PLANNING APPLICATION. ALDWICK

AW/25/15A

I am writing to object to the above
AW/25/15A signage outside MORRISONS.

DRAWING
PROPOSED SIGNAGE SITE PLAN
PROJECT
**THE SHIP INN
ALDWICK STREET
BOGNOR REGIS PO21 3AP**

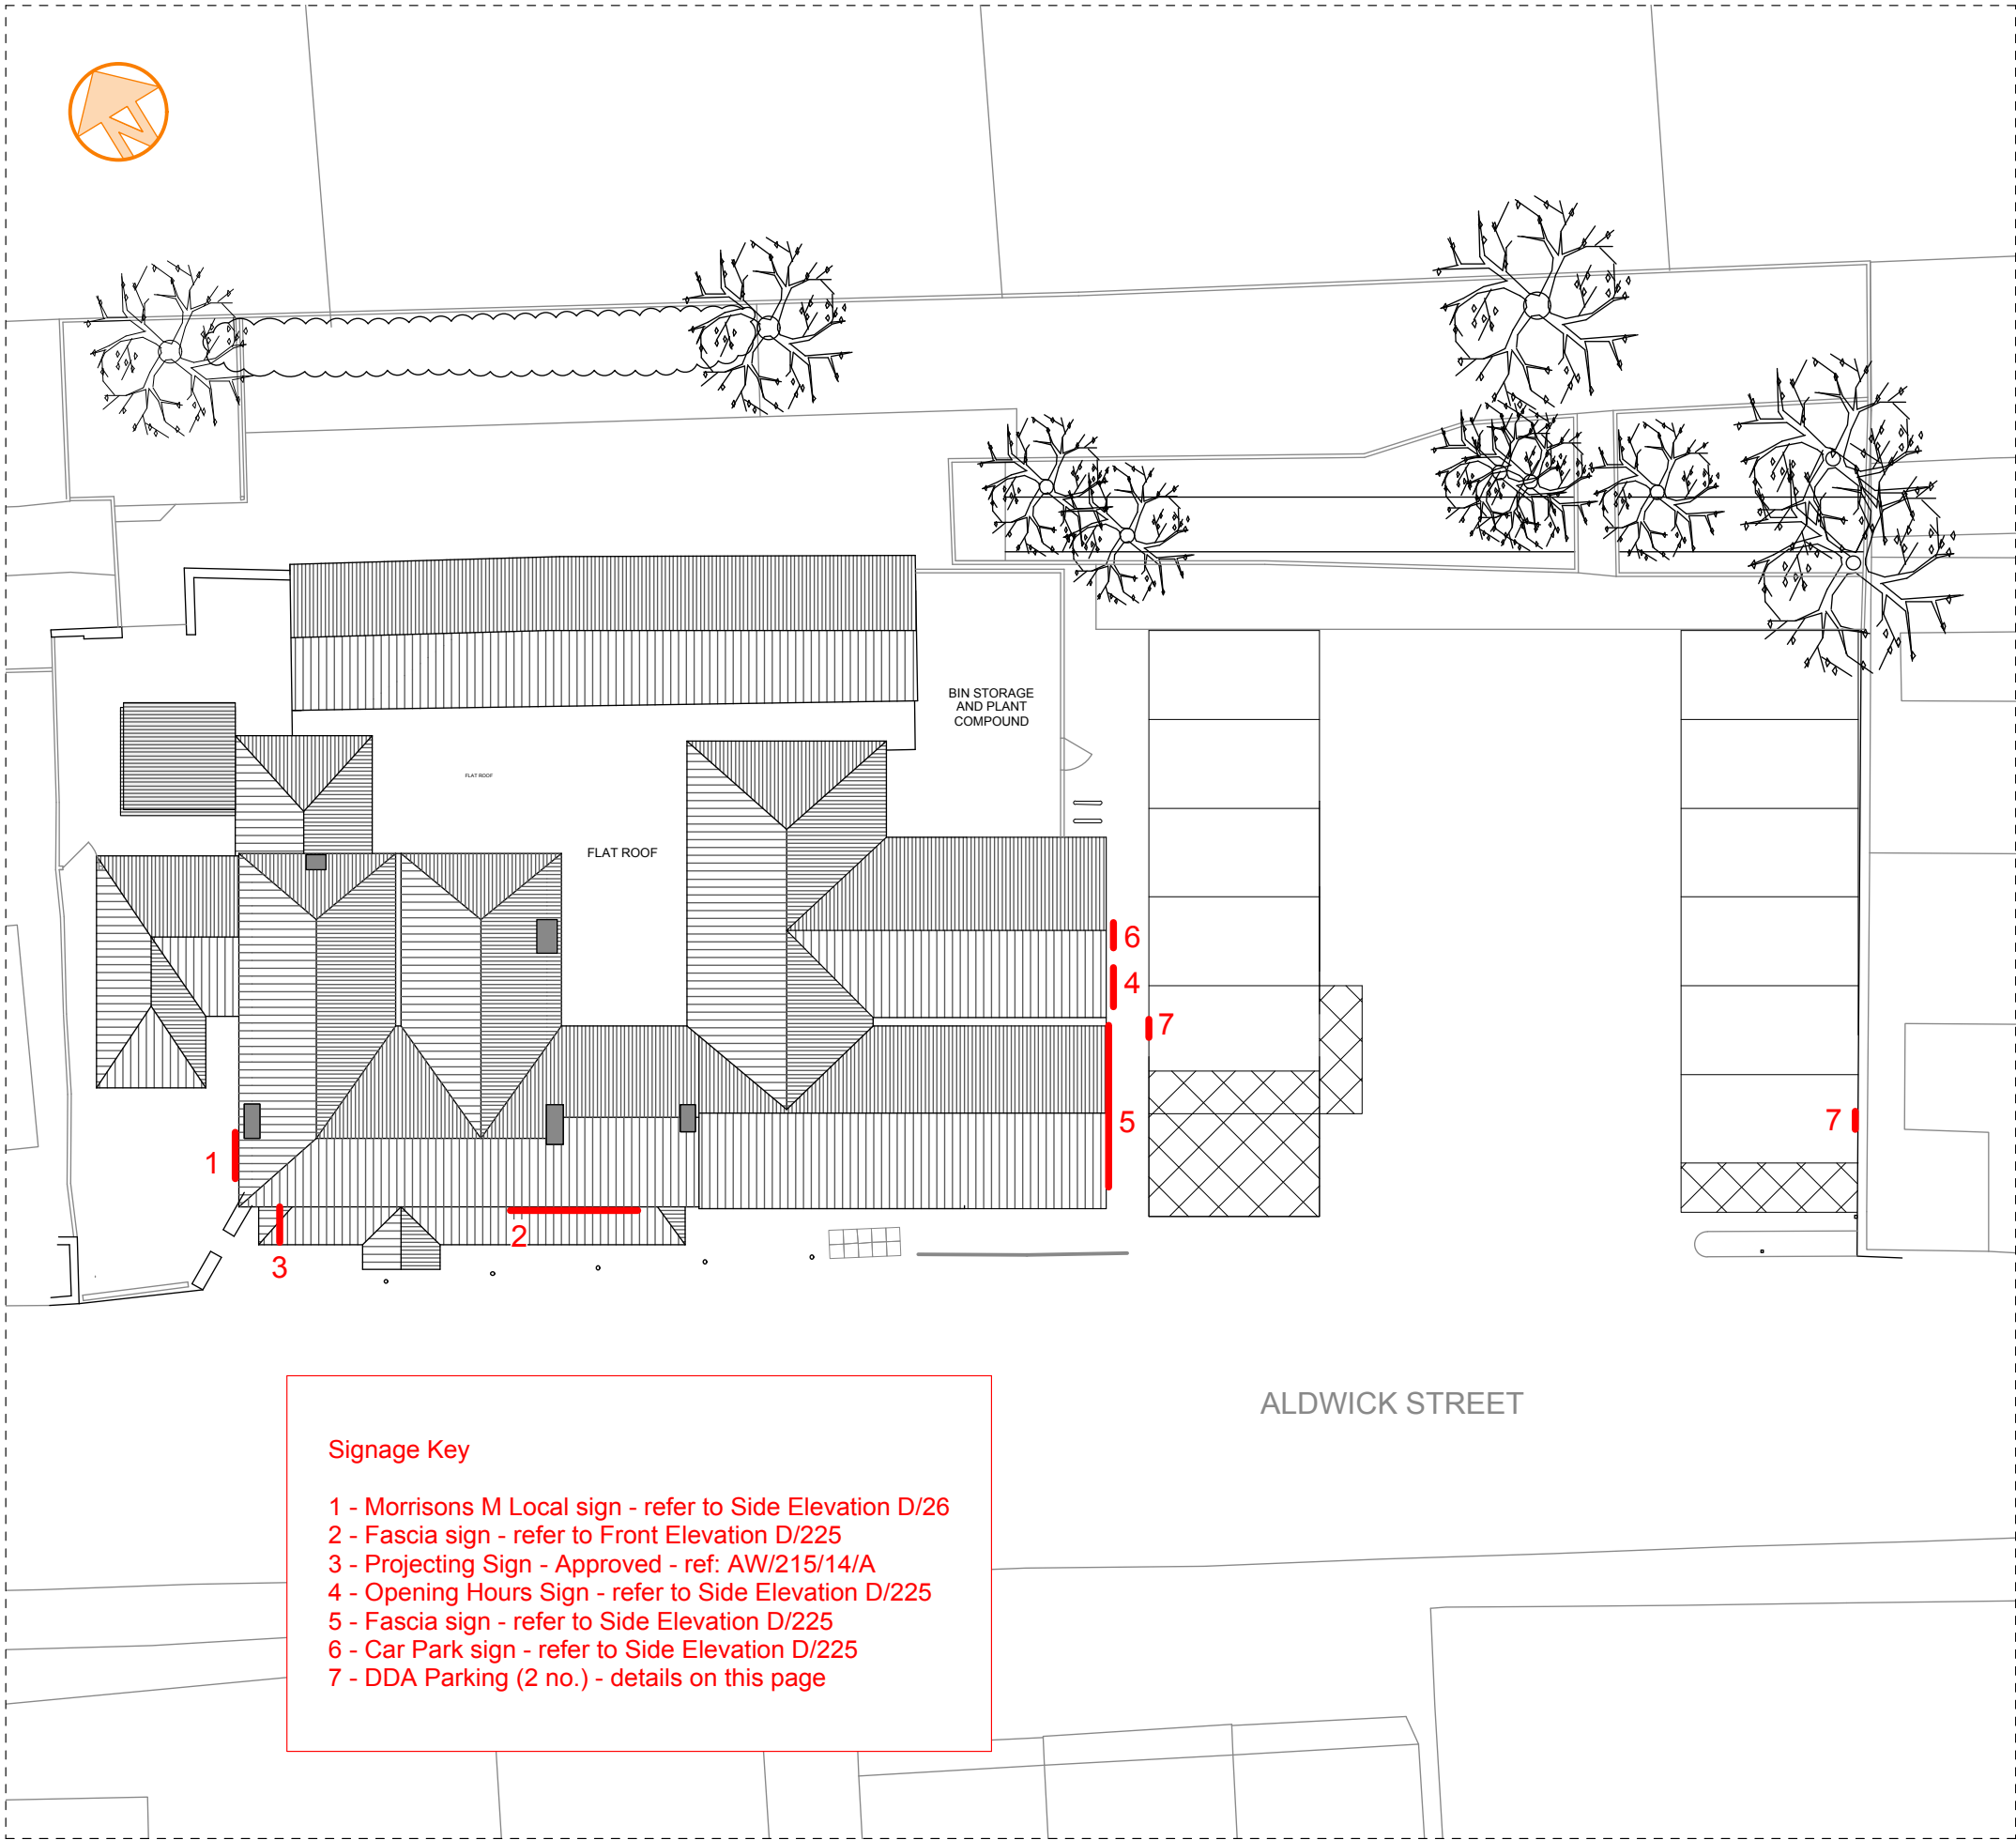
1/ Six Signs on such a small
site makes no sense at all.

2/ Four Signs to be externally
illuminated, causing pollution to
local residents, no other business in
Aldwick has so many signs. Why so
many in a small area. It will be like
Blackpool.
